Application Reference: 2026/0074

Site Address: 13 Fitzwilliam Street, Hoyland Common, Barnsley, S74 0NJ

Introduction: Formation of hardstanding and boundary wall to provide 1 no. enclosed off street parking space.

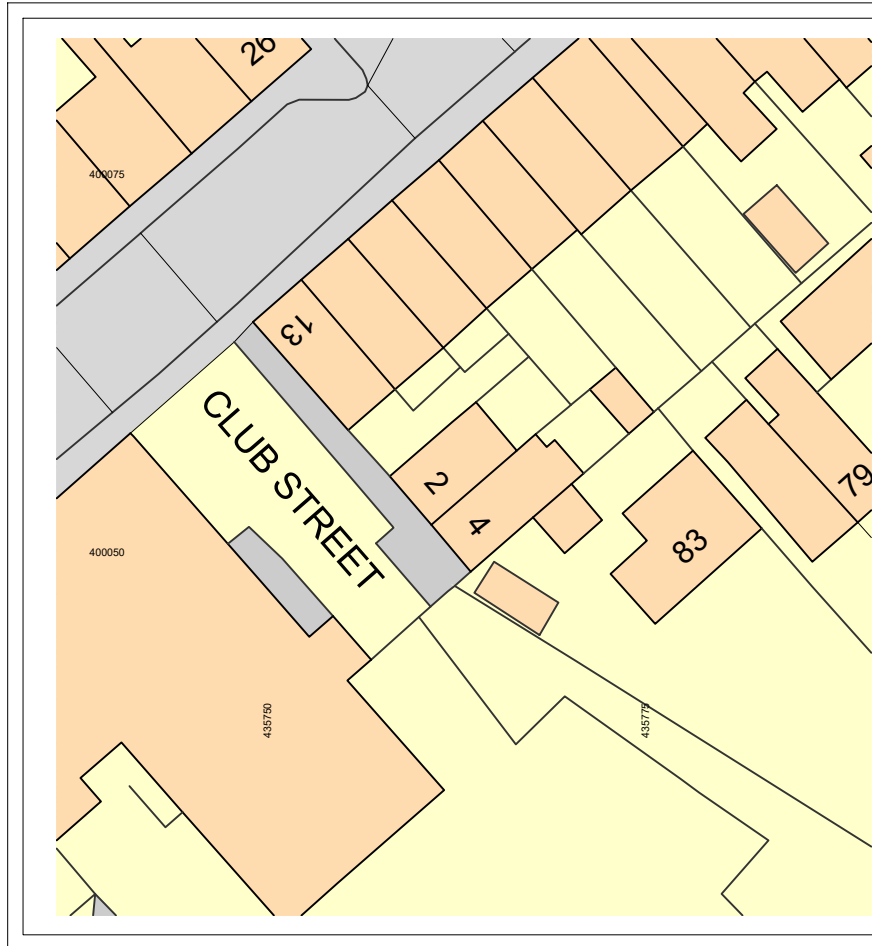
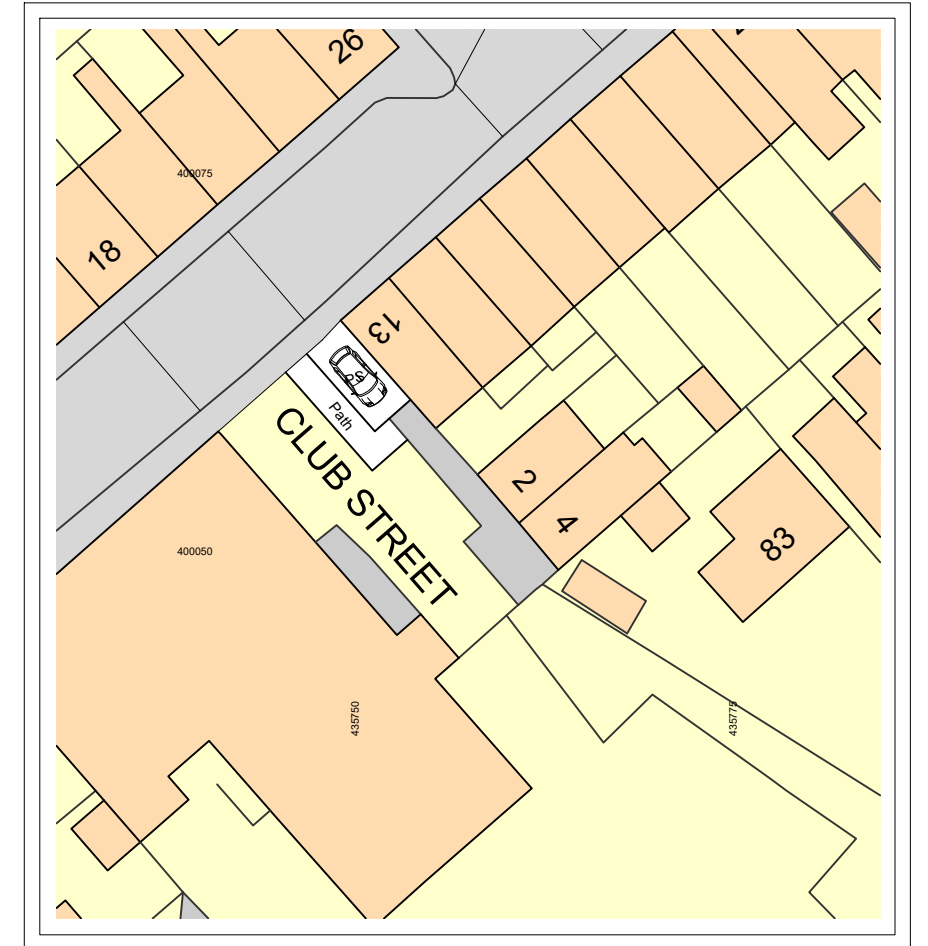
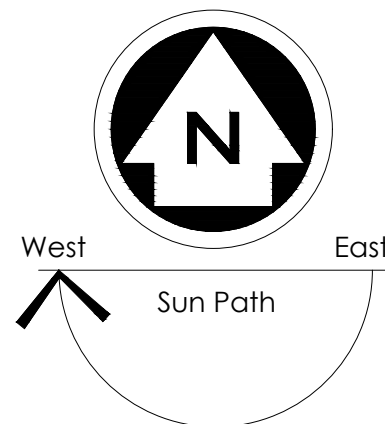
The proposal is positioned directly adjacent to the site dwelling. As a result, views to the northeast of the access are severely restricted. Pedestrian visibility splays of 2m x 2m cannot be achieved on exiting the parking space as a result of the proximity to the existing dwelling. This gives rise to highway safety concerns and would detrimentally impact on highway safety.

The proposal would therefore have an unacceptable impact on highway safety as a result of inadequate pedestrian visibility splays. Additionally, the proposal has the potential to result in excessive pressures on the existing on-street parking which could result in obstructions and restricted vehicle manoeuvrability impacting on emergency services and local business deliveries.

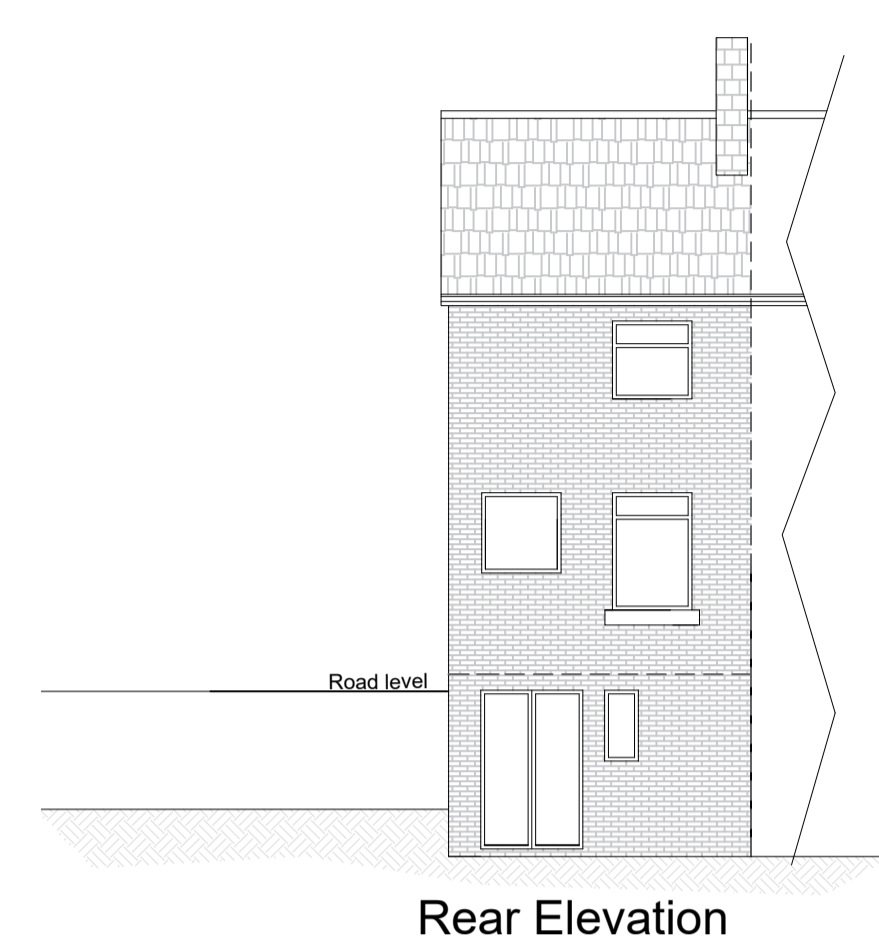
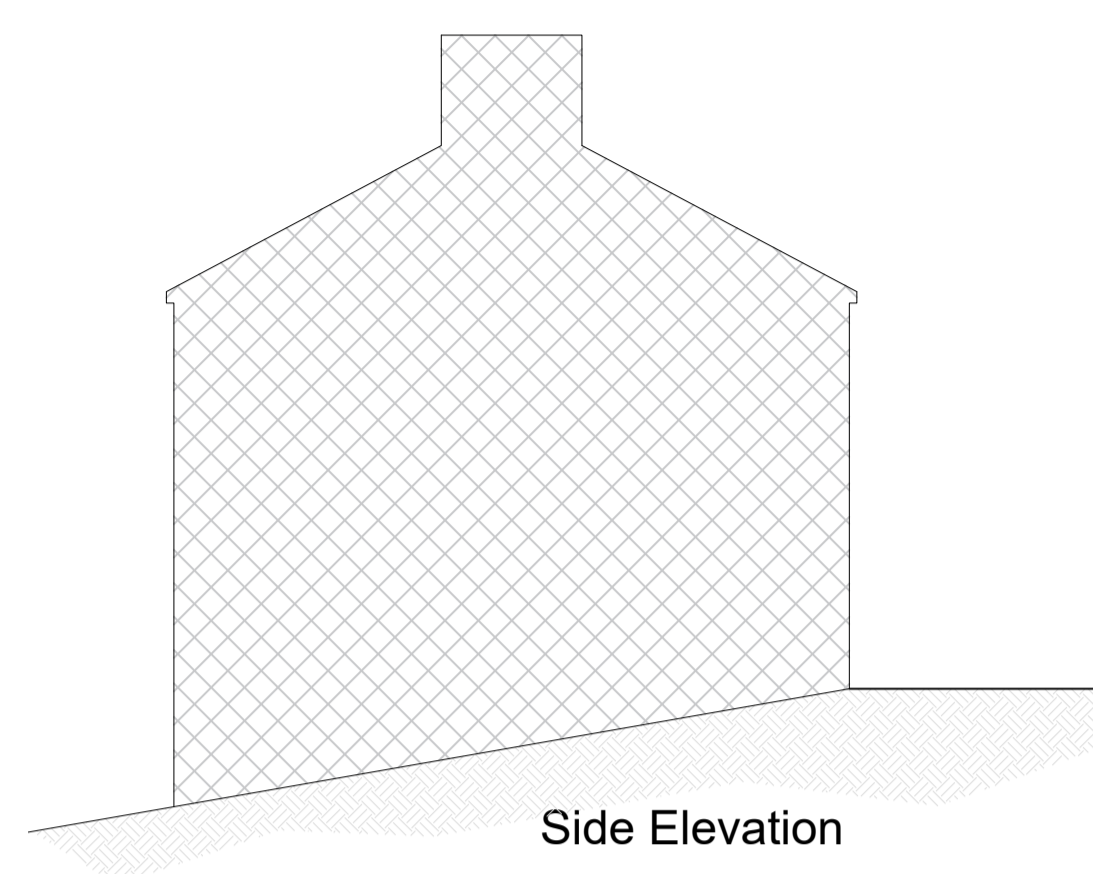
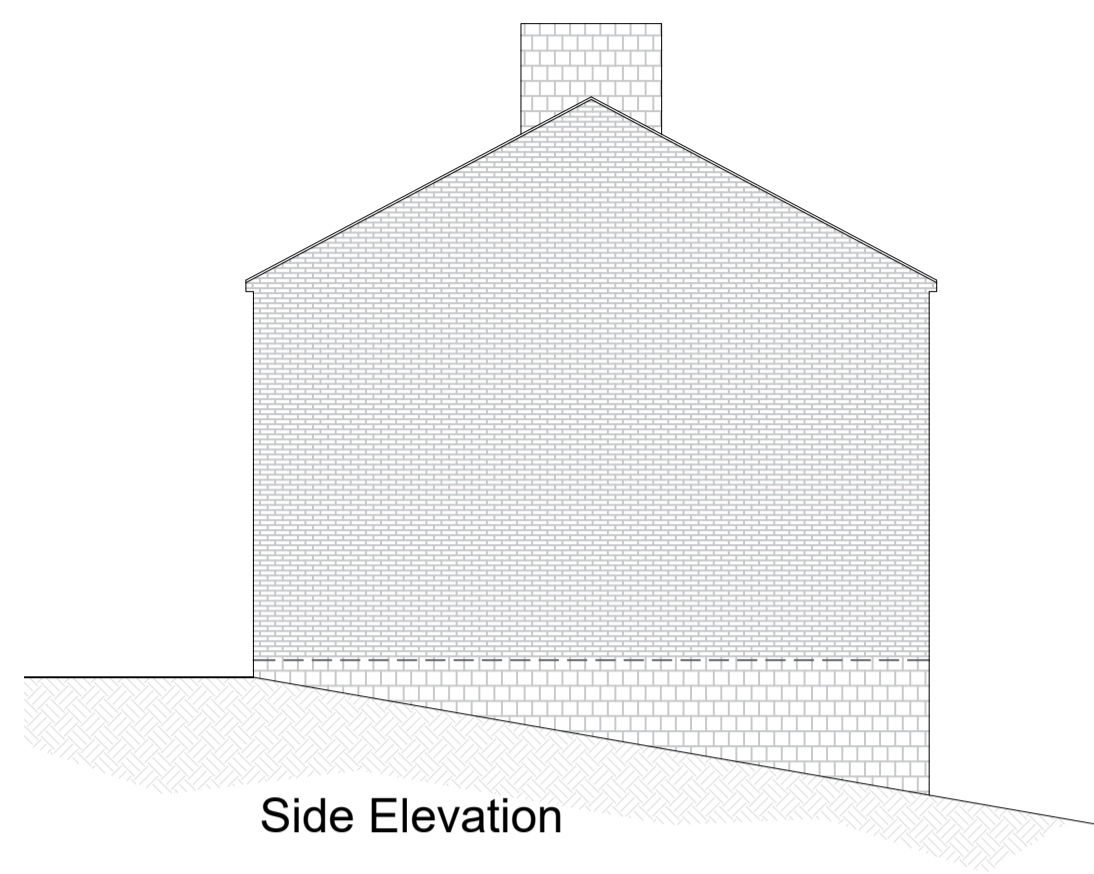
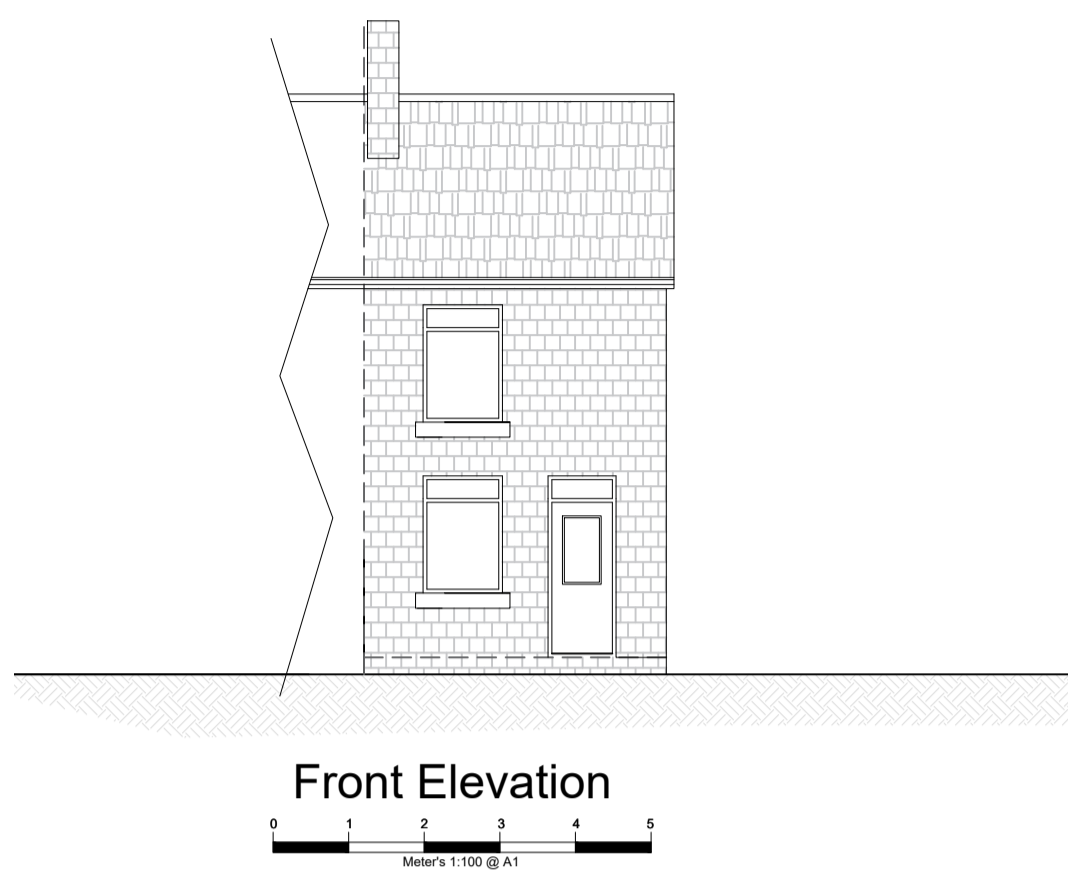
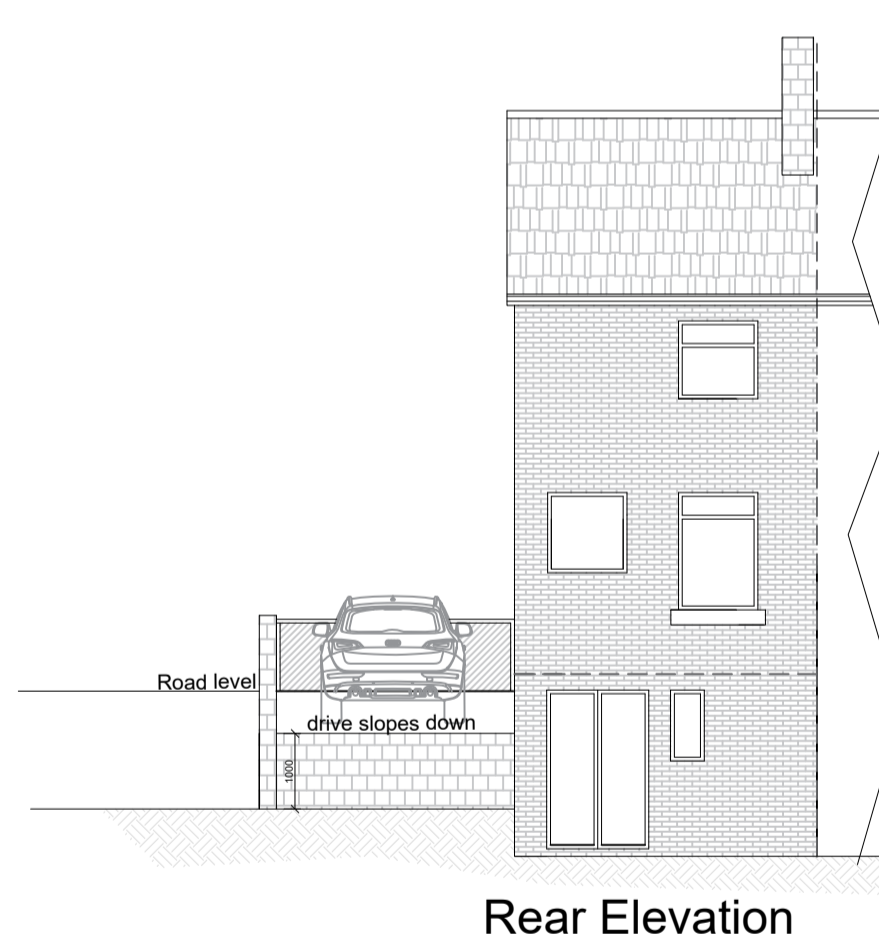
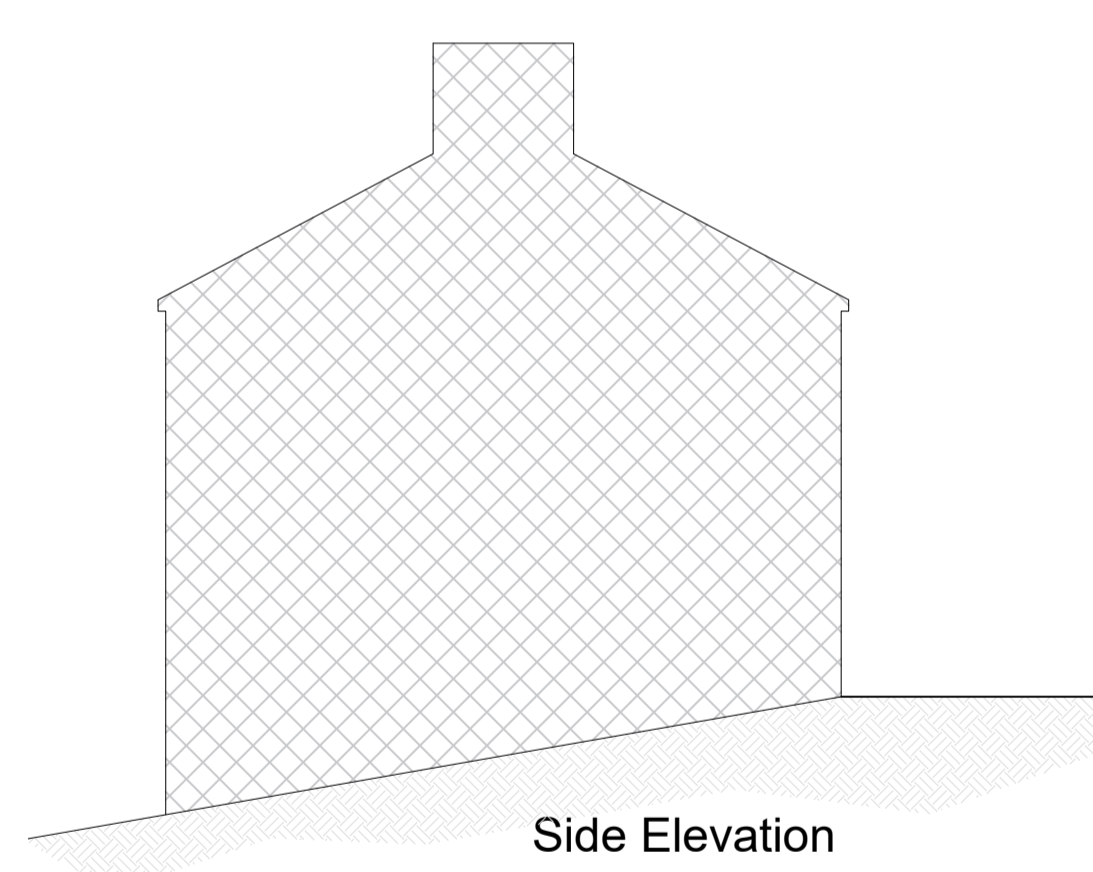
The proposal would not significantly detract from the character of the street scene. The wall is proposed to be at a modest height of 1 metre and detailed to be constructed from matching stonework to the front elevation of the associated dwelling allowing the proposal to match the character of the site and street. The proposed gate is also considered to be low level and would have minimal impact on the character of the street scene. The location of the wall is considered to be in a prominent location, however given the small nature of the wall and hardstanding, would not be detrimentally impactful on the character of the street scene.
